From: Laura Gibbons
Sent: 14 March 2019 12:36
To: Michael Eastham; Planning.Responses
Subject: WA/95/18/RES

Engineers Comments Regarding Surface Water Drainage

Drawing Title:
PROPOSED OFF-SITE CULVERT WORKS

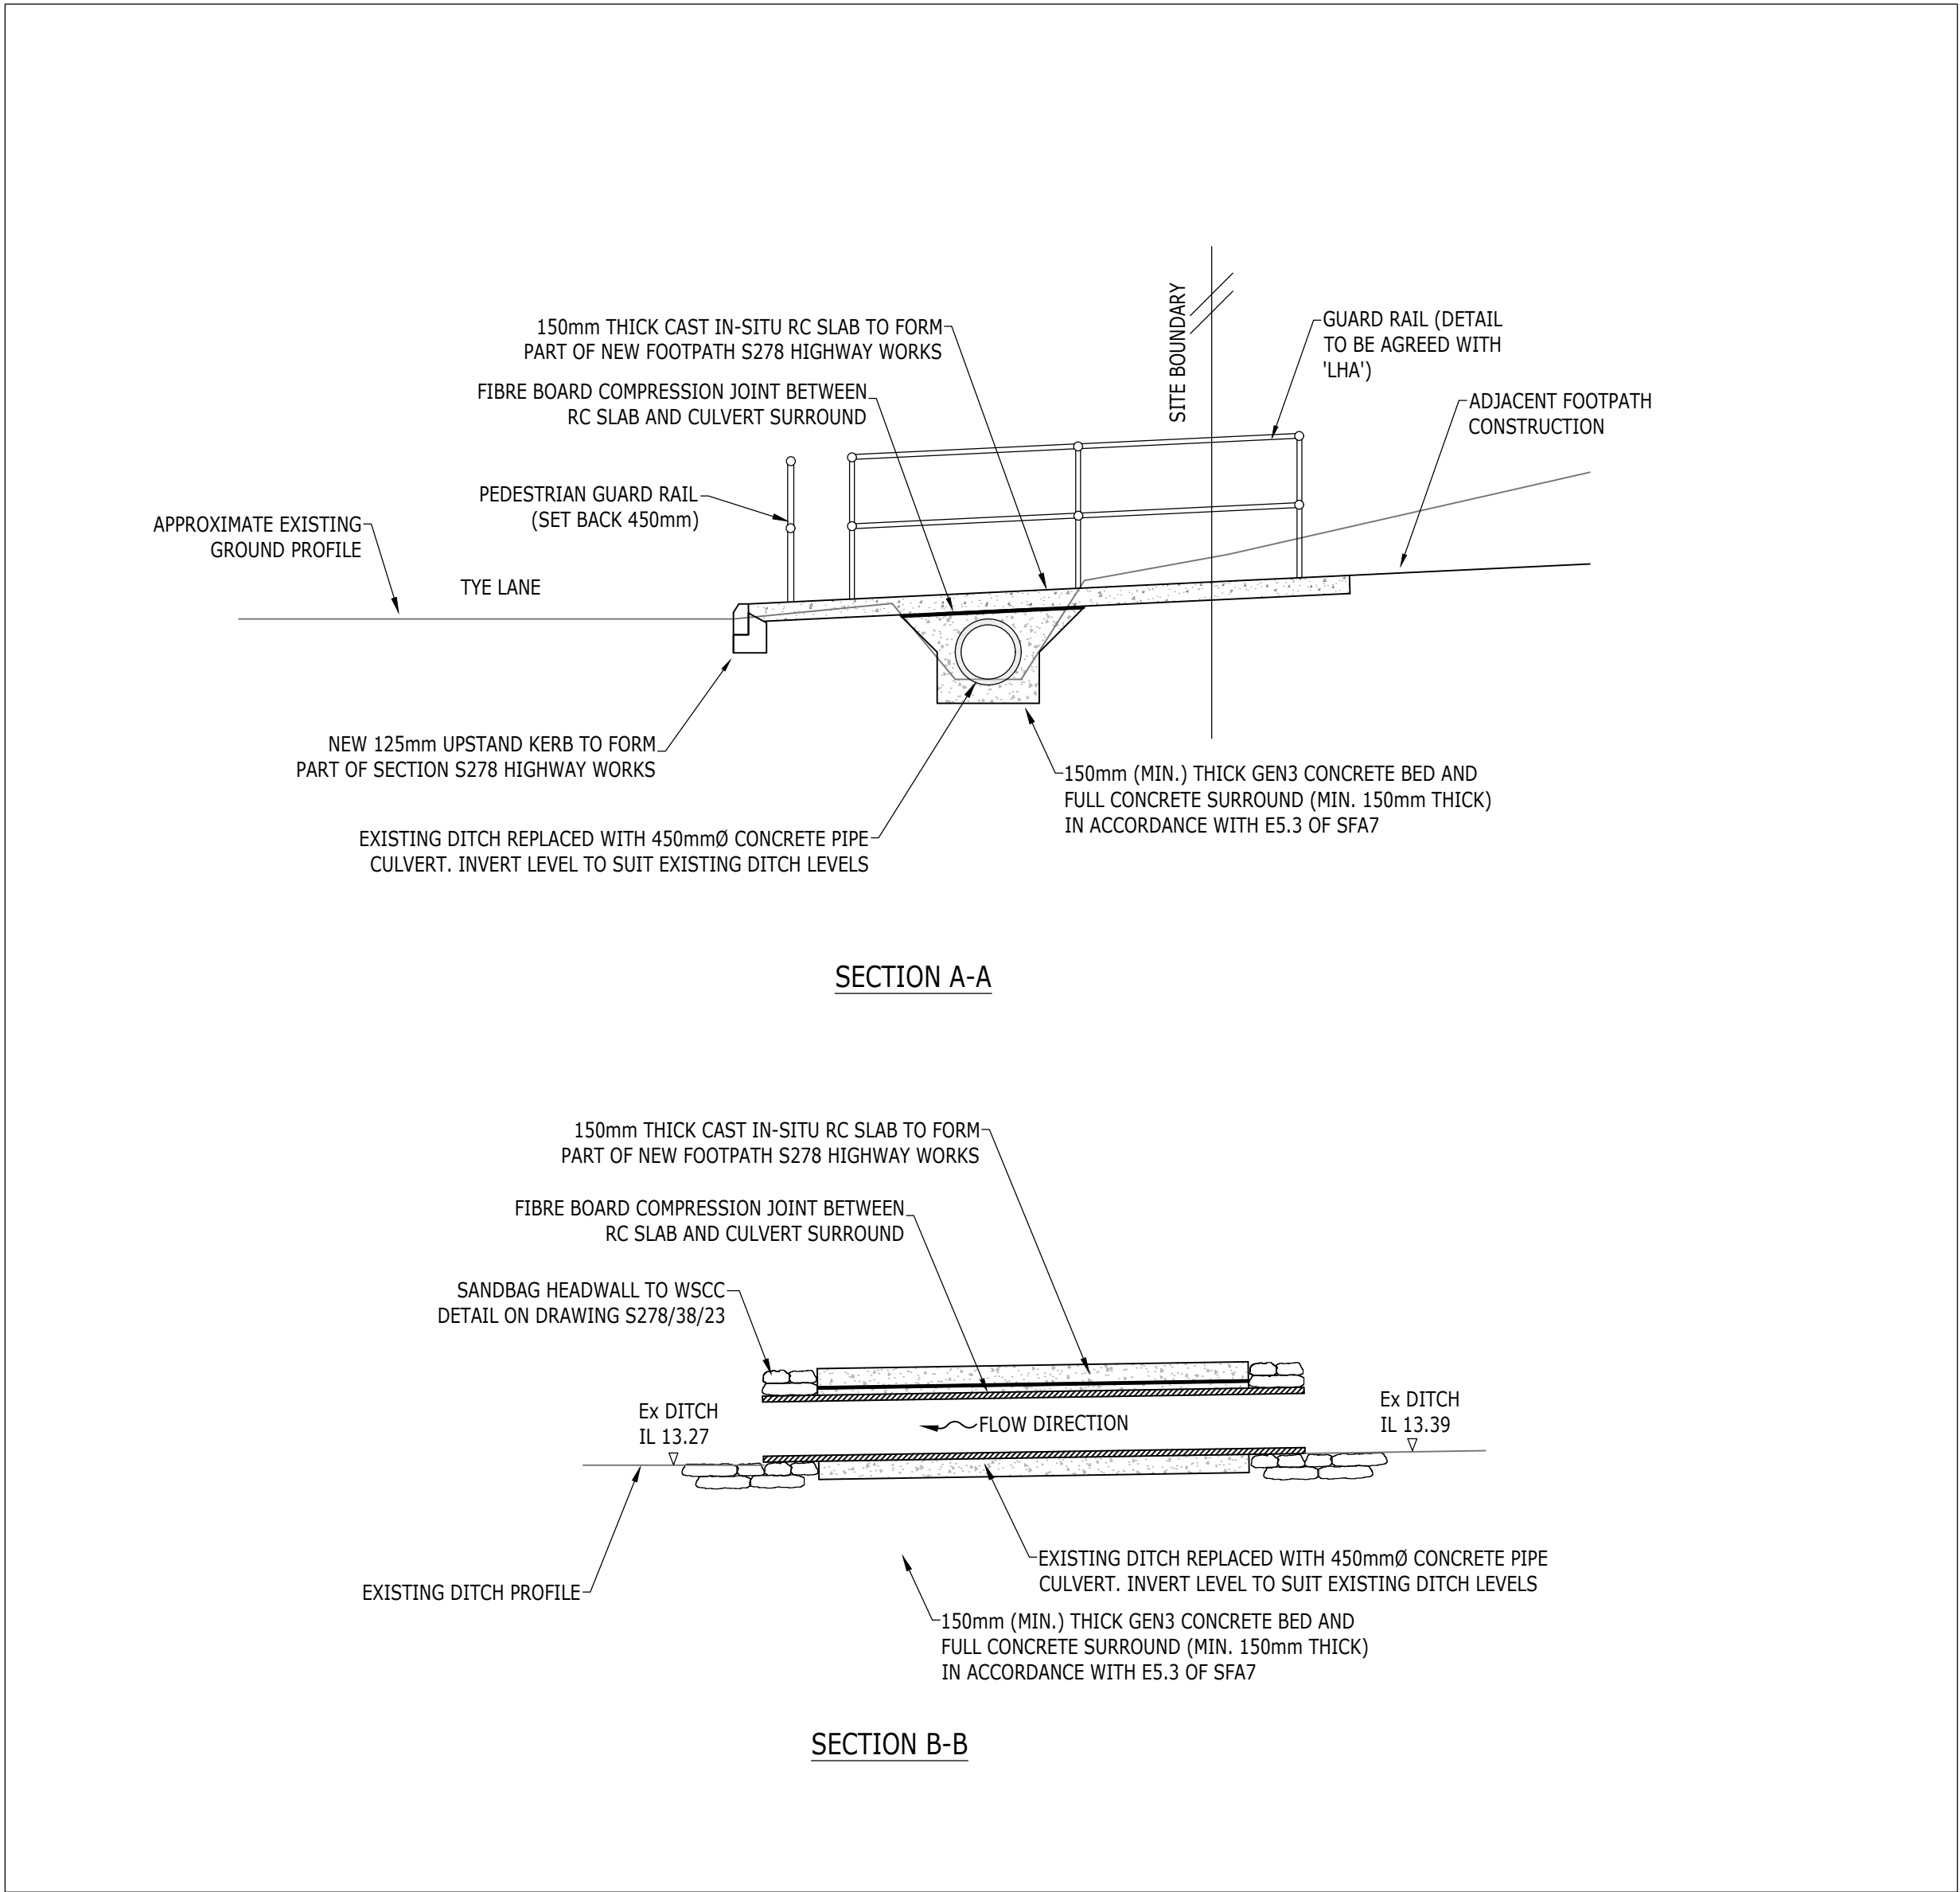
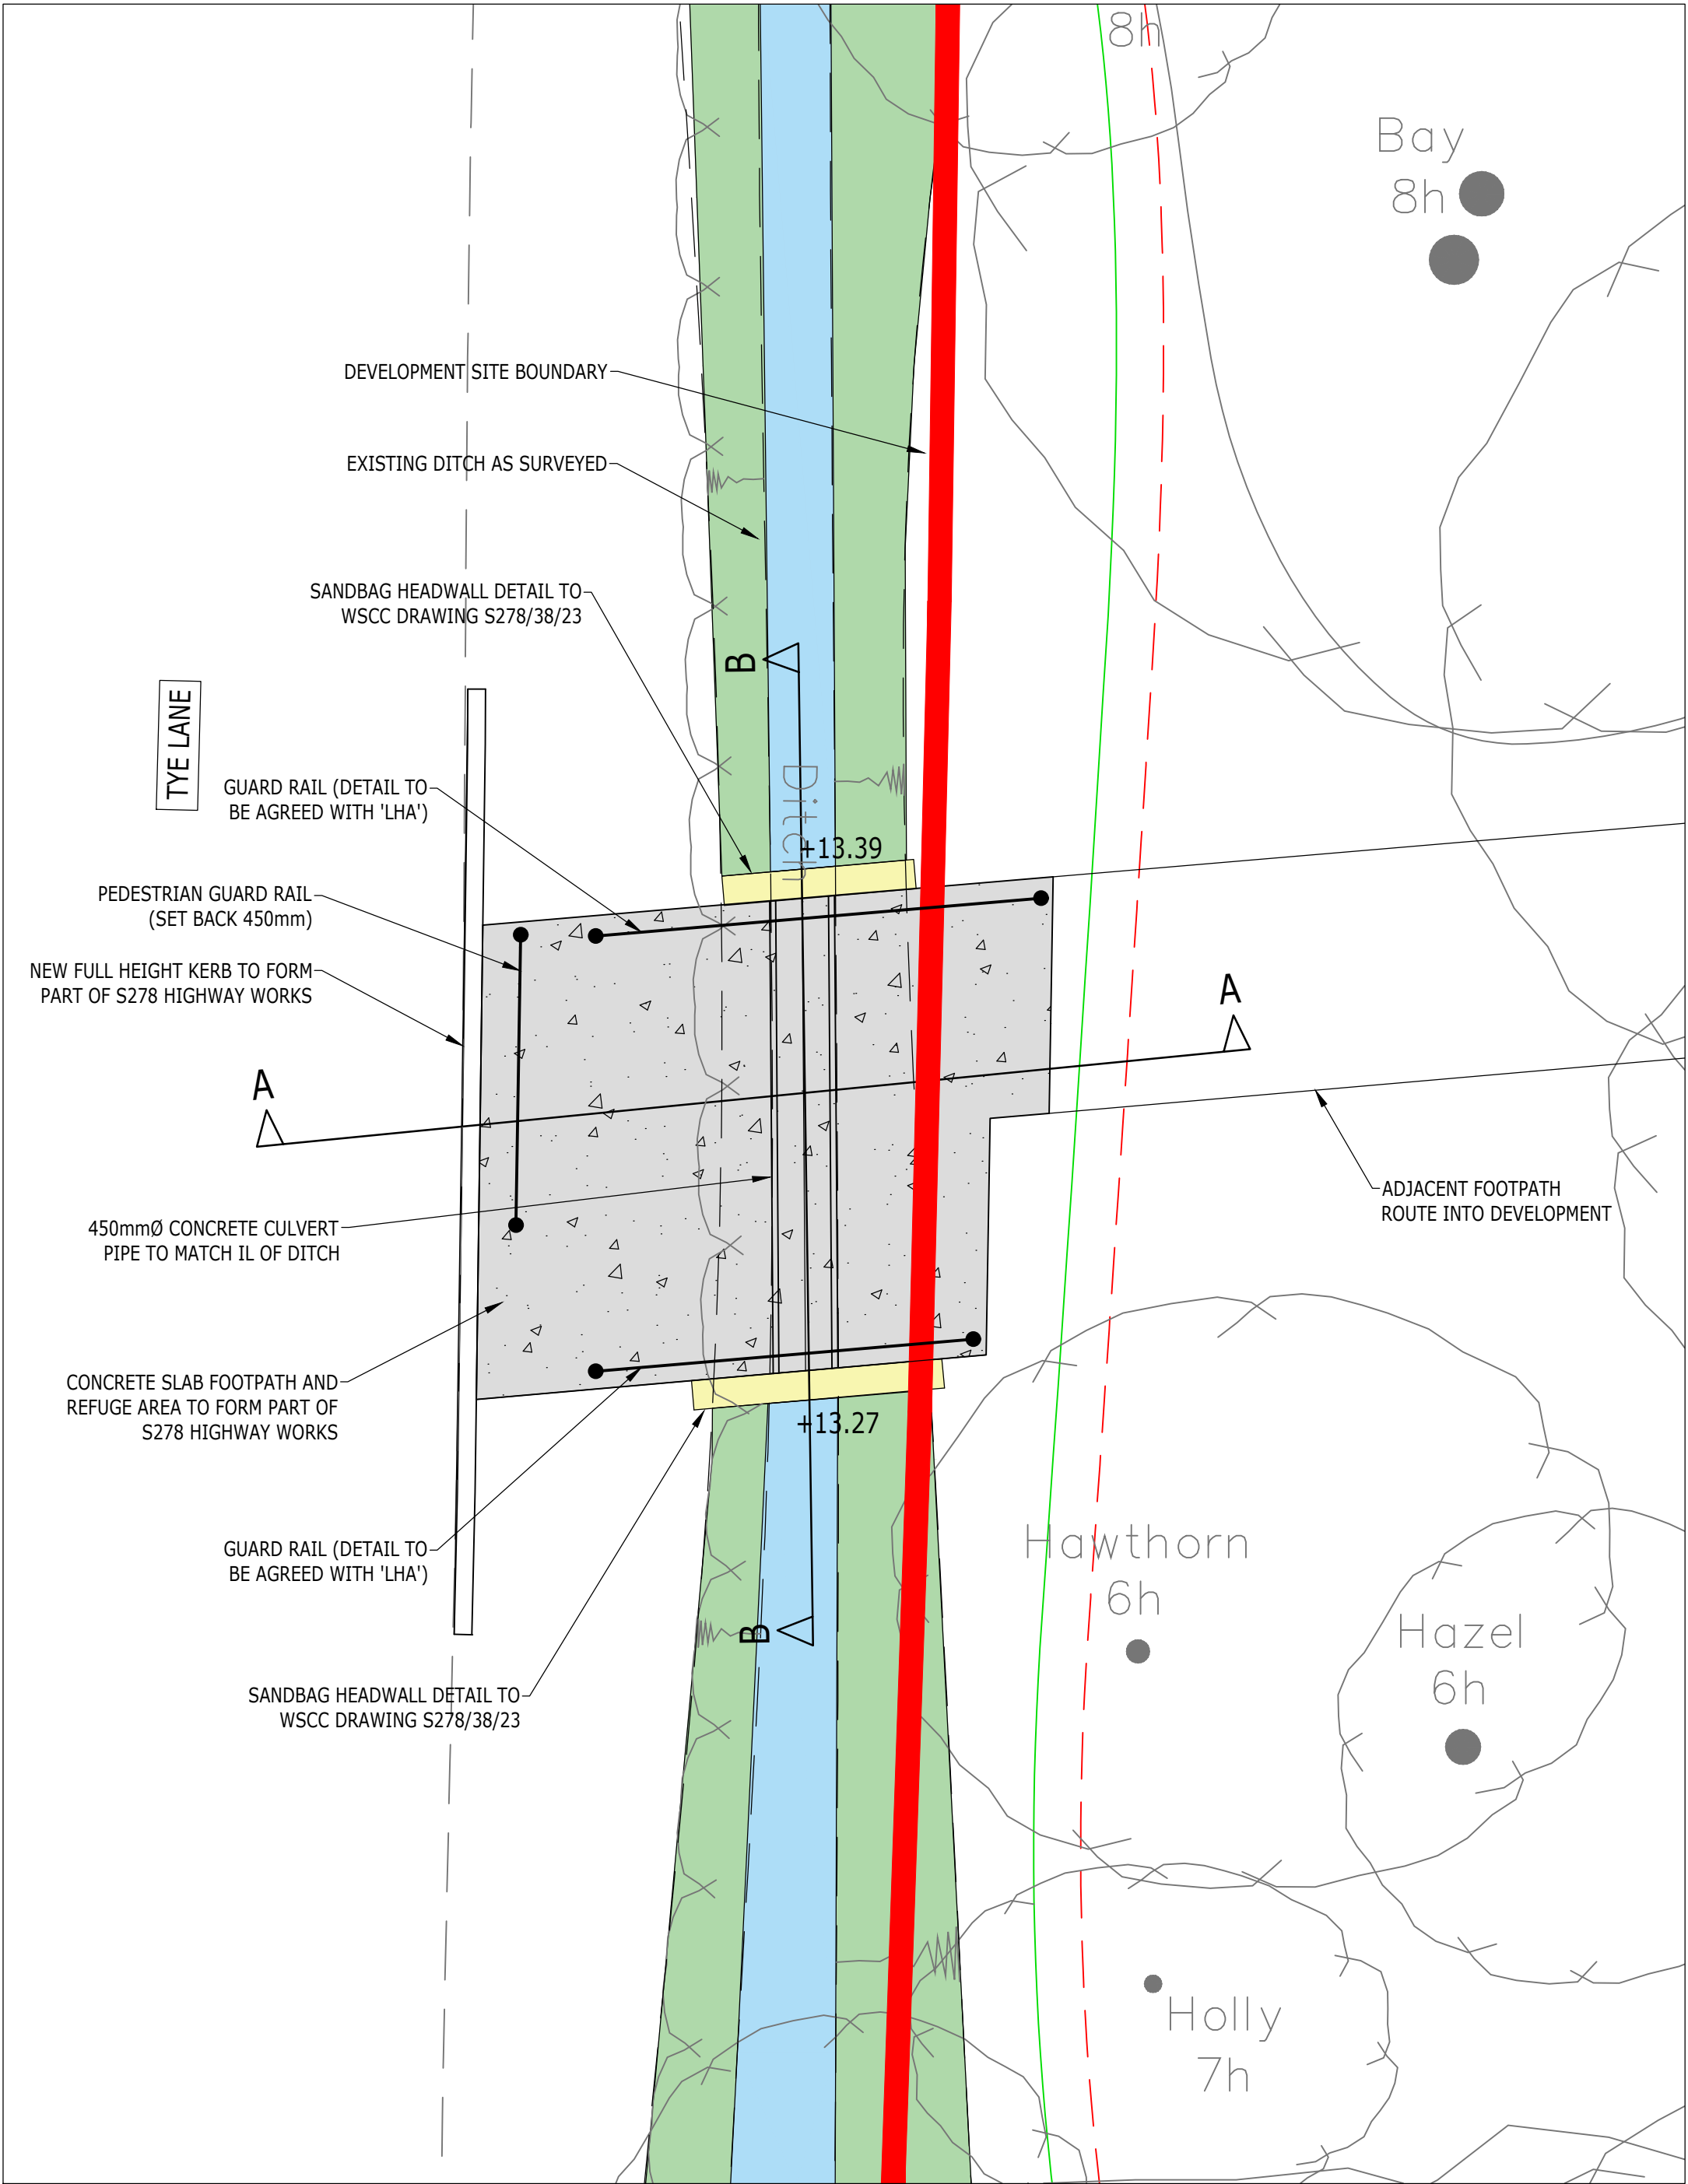
The layout proposes a new link on to Tye Lane, this proposal requires a short section of ordinary watercourse to be culverted. Preliminary designs have been provided for this. Although there are points outstanding regarding the design I am confident that ordinary watercourse consent will be obtainable in due course.
